ADC PARKS & GREENSPACE ARBORICULTURE

PLANNING APPLICATION: AW/307/14/TC

ADDRESS: 12 The Drive, Aldwick. PO21 4DU

BRIEF DESCRIPTION: Fell 4 No Fir trees

SKETCH PLAN

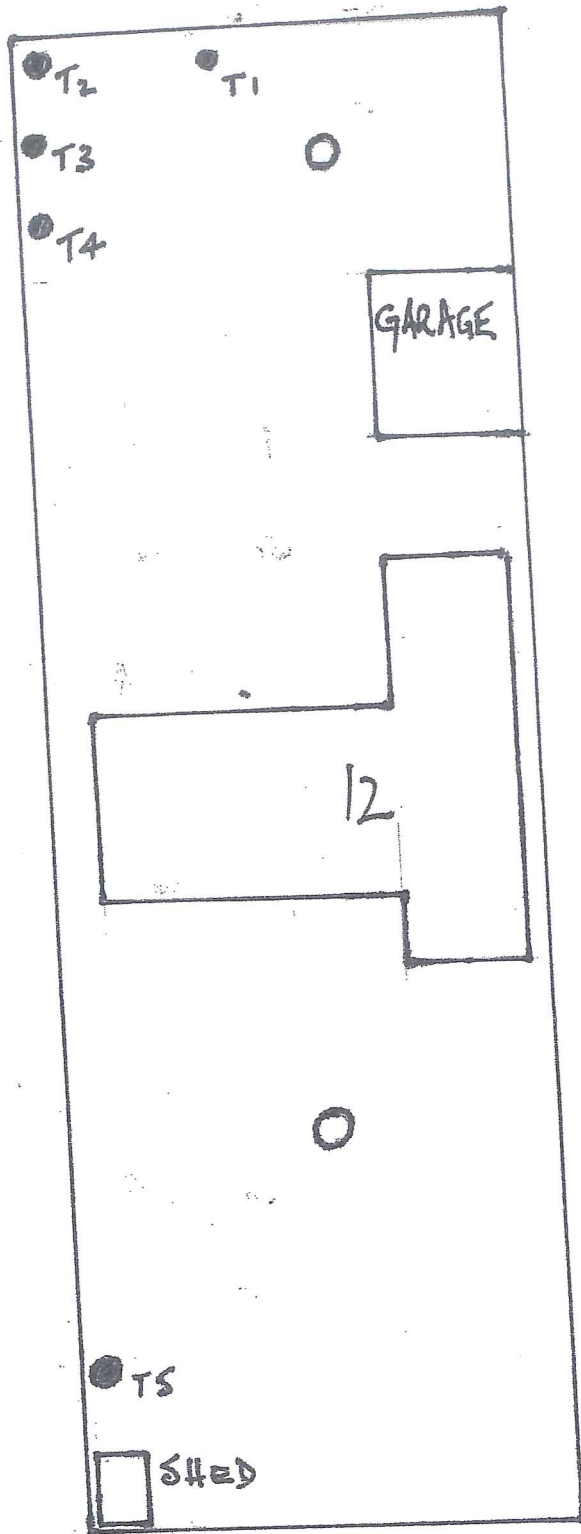
- **T1 – T3** are all smaller trees that are in poor condition, showing large amounts of die-back occurring in the crowns. This has affected the aesthetical value offered by these cited trees. All three trees scored under 8 of the TEMPO form, and therefore would not be suitable for a TPO order.

- **T4** is slightly larger than trees **T1 – T3**. It too has die-back across the crown. This also means this tree has poor overall condition and the aesthetical value offered. This tree scored a 9 on the TEMPO form, so would not be suitable for a TPO order.

- As the outlined trees are not suitable for a TPO order, I have no objection to this application.
